Reference No:	2026/62/90591/W
Site Address:	4, Longley Road, Almondbury, Huddersfield, HD5 8JL
Description:	Alterations to convert garage into habitable space and erection of first floor front and side extension and single storey rear extension
Recommending Officer:	Joshua Merriman

DECISION – FULL CONDITIONAL PERMISSION

Officer Report – 2026/90591

Proposed Elevations

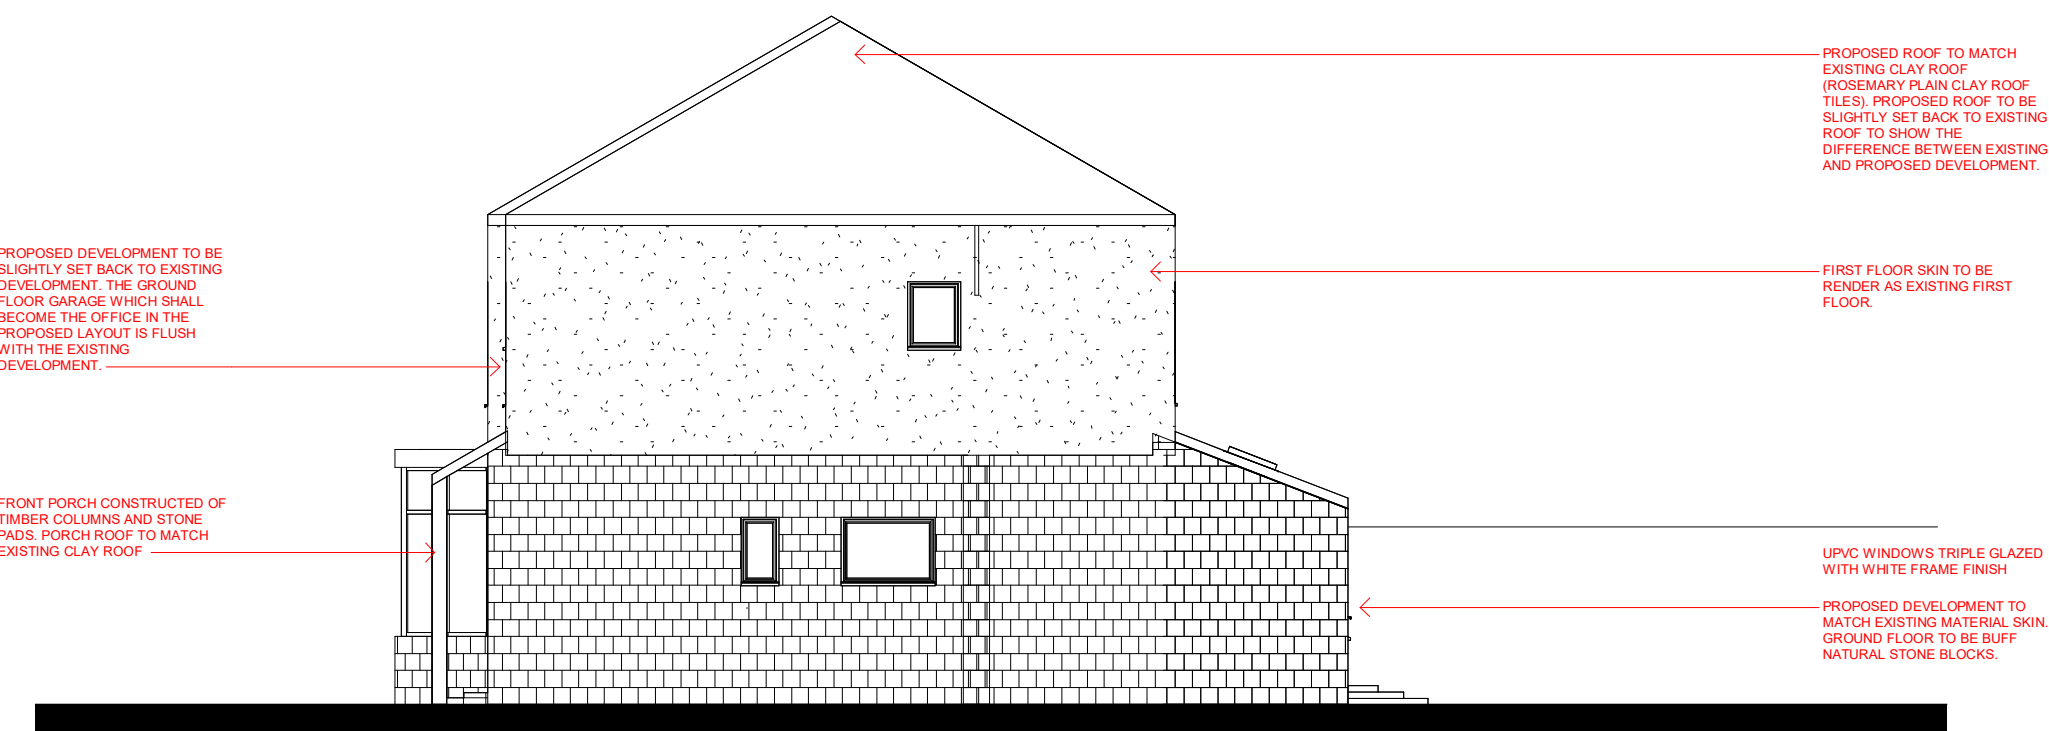
The first-floor side extension is considered to be visually smaller in relation to the original house, is set back at least 500mm from the front elevation of the original house and has a roof design which follows and is sympathetic to the original roof.

The extension also uses matching materials to the original dwelling, including stone and render, red clay roof tiles, uPVC windows, and composite doors, ensuring a sympathetic appearance to the host dwelling and surrounding street scene.

The front extension is set well back from the highway, is subservient to the existing property, and will use the aforementioned matching materials to ensure a sympathetic appearance.

As for the single storey rear extension, it will be set entirely behind the existing building, not projecting beyond the sides, will remain small and subservient to the existing property and garden, and will also use the same matching materials as other extensions in the development.

Finally, the garage conversion will introduce a new window to the front elevation in place of the existing garage door, which will be uPVC to match the existing dwelling, and is considered to be proportionate to all windows existing in the property regarding size and scale and thus will have no significant impacts visually.

Proposed Plans

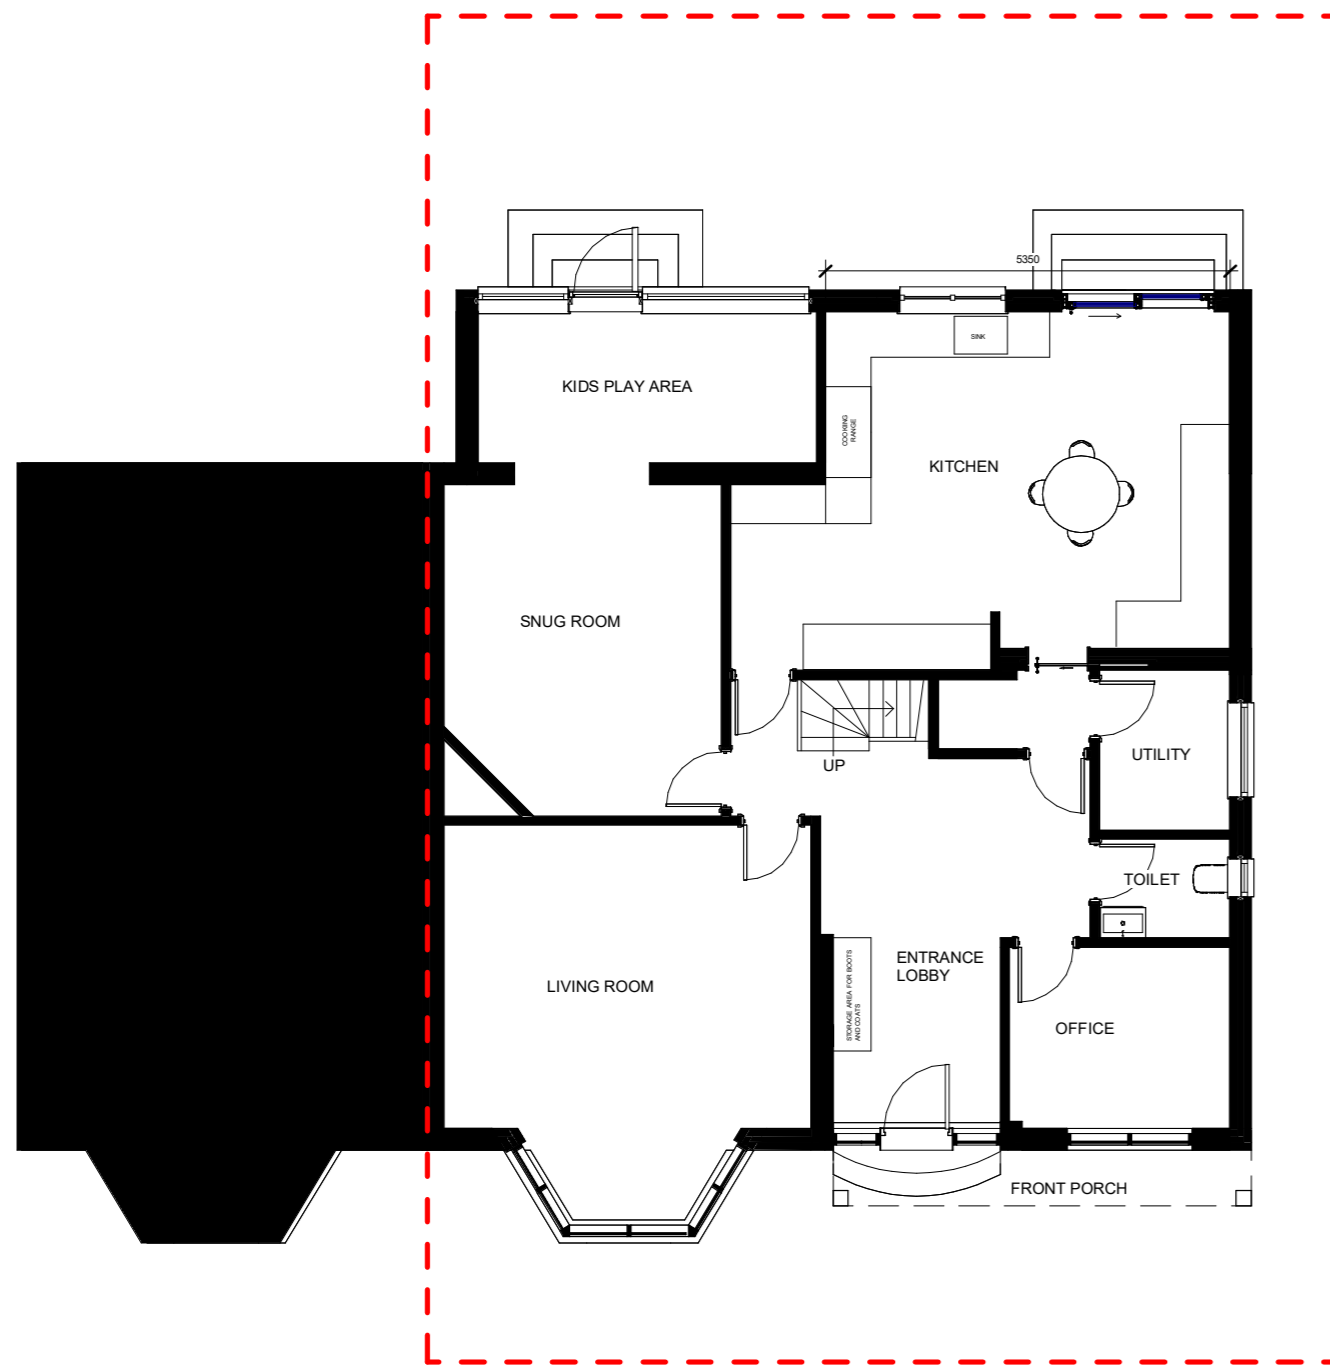
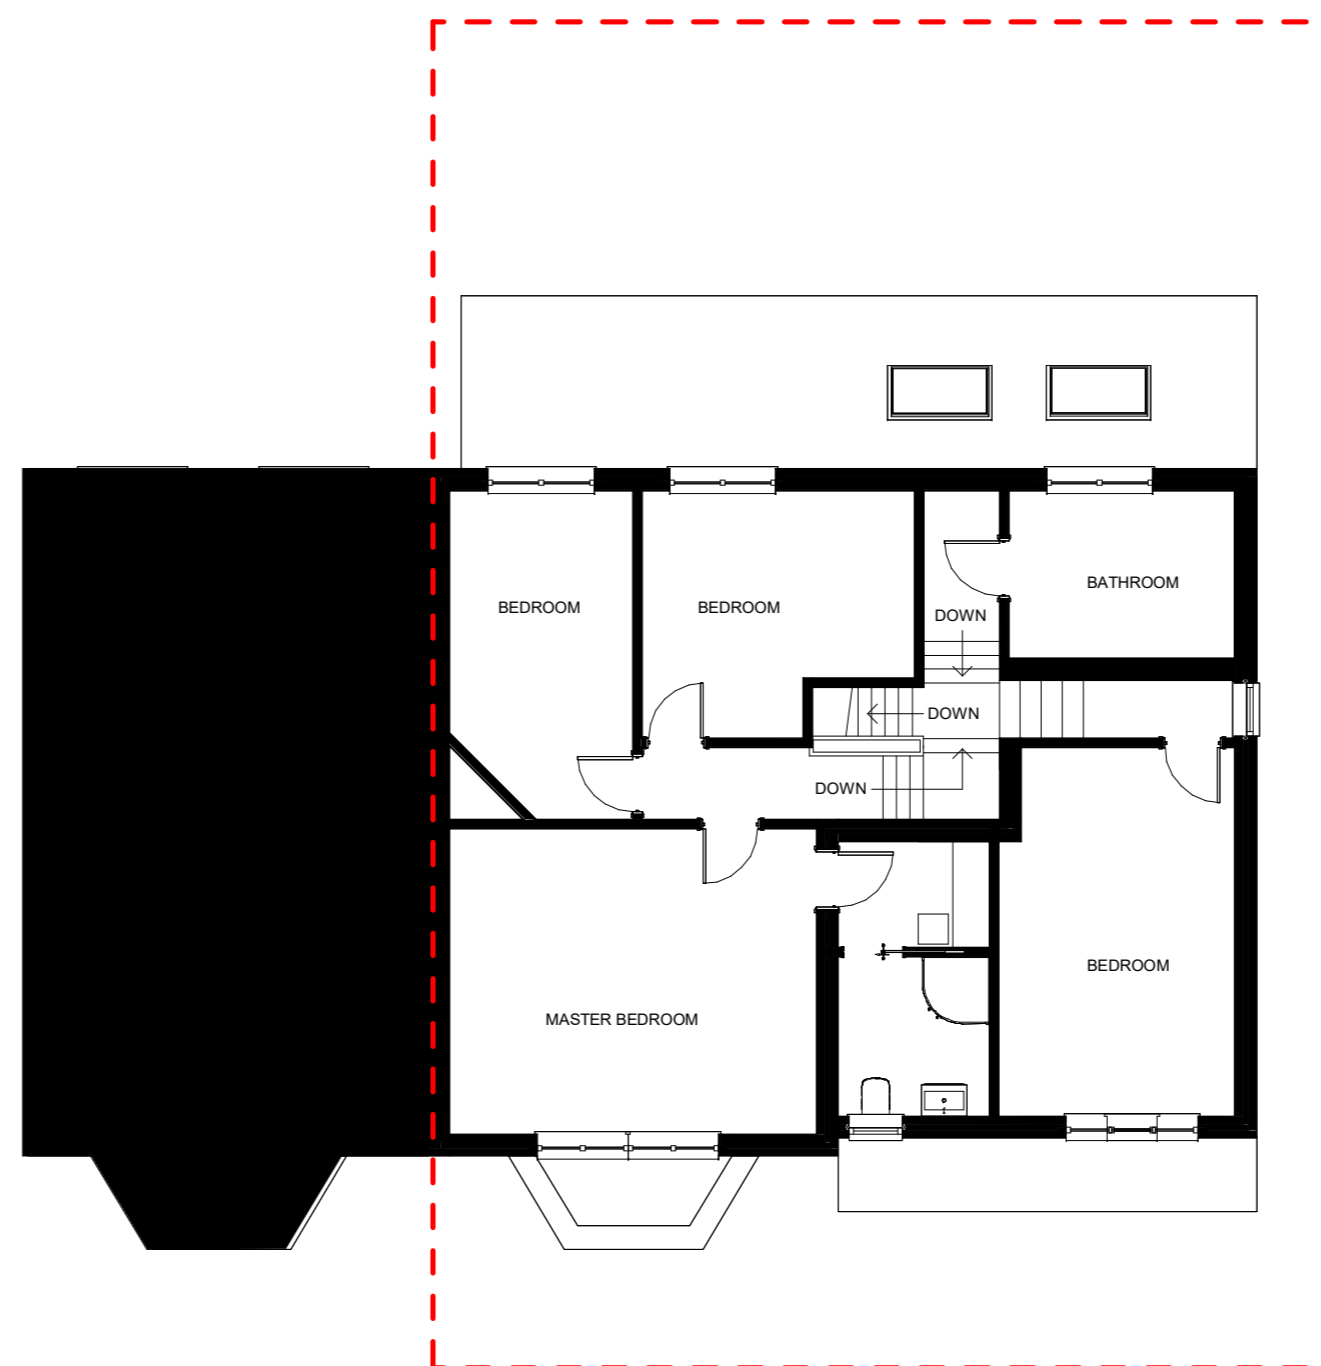
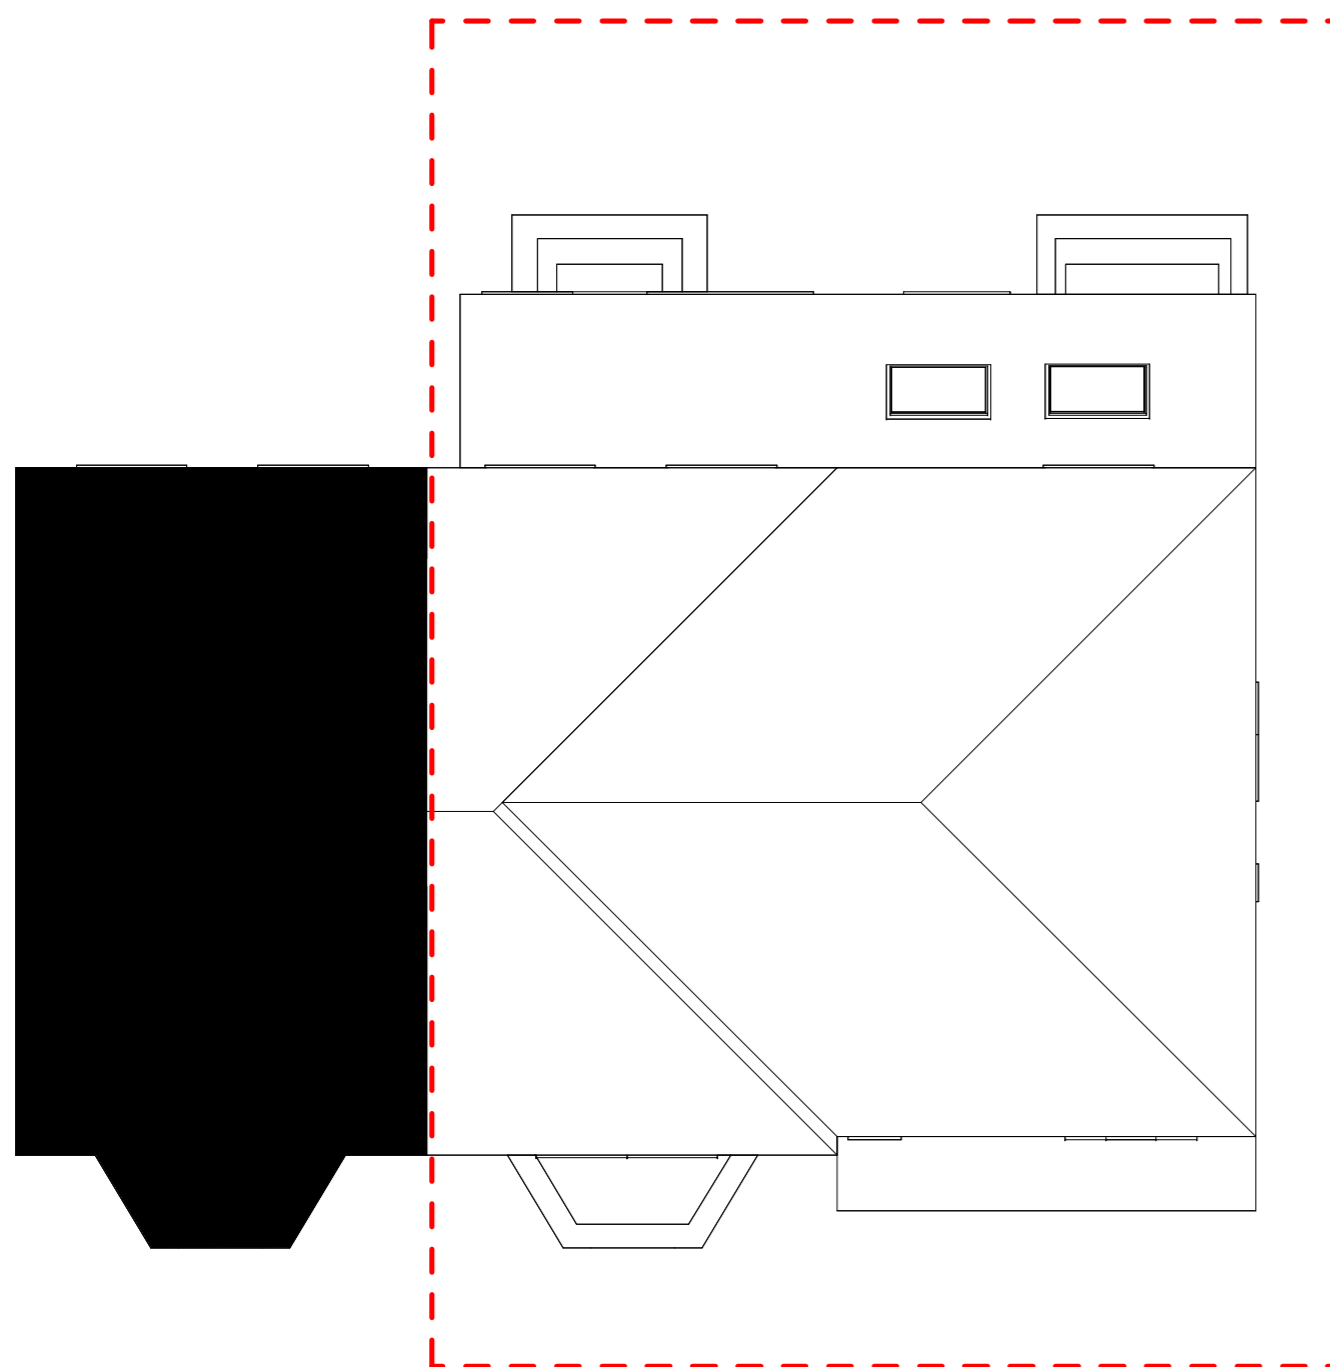
The proposed first floor extension does not remove any current amenity space at the dwelling as it is located above an existing single storey element of the dwelling, and does not increase the footprint of the dwelling. The existing external access to the area of rear amenity space will also be maintained. Despite the extension not retaining a 1m gap to the side boundary, the extension will lie above the existing footprint of the property, therefore, not encroaching further towards the neighbouring property and is not considered to cause any additional impacts upon residential amenity of neighbouring occupiers.

Given the limited scale of the front and rear extensions, and the minor external alterations of the garage conversion, none of these elements are considered great enough in scale to have any overshadowing, overbearing, light, or outlook impacts upon neighbouring properties. Furthermore, any new window openings are considered to be an adequate distance and sufficiently angled from neighbouring properties as to have no significant impact upon privacy or overlooking.

The openings servicing the new ground floor toilet will be obscured via condition to ensure no impacts upon residential amenity.

4. The proposed toilet window in the North East facing elevation shall be fitted with obscure glazing to at least Level 3 on the Pilkington Scale (or equivalent) and be non-opening to a height of no less than 1.7m above floor level and retained as such thereafter.
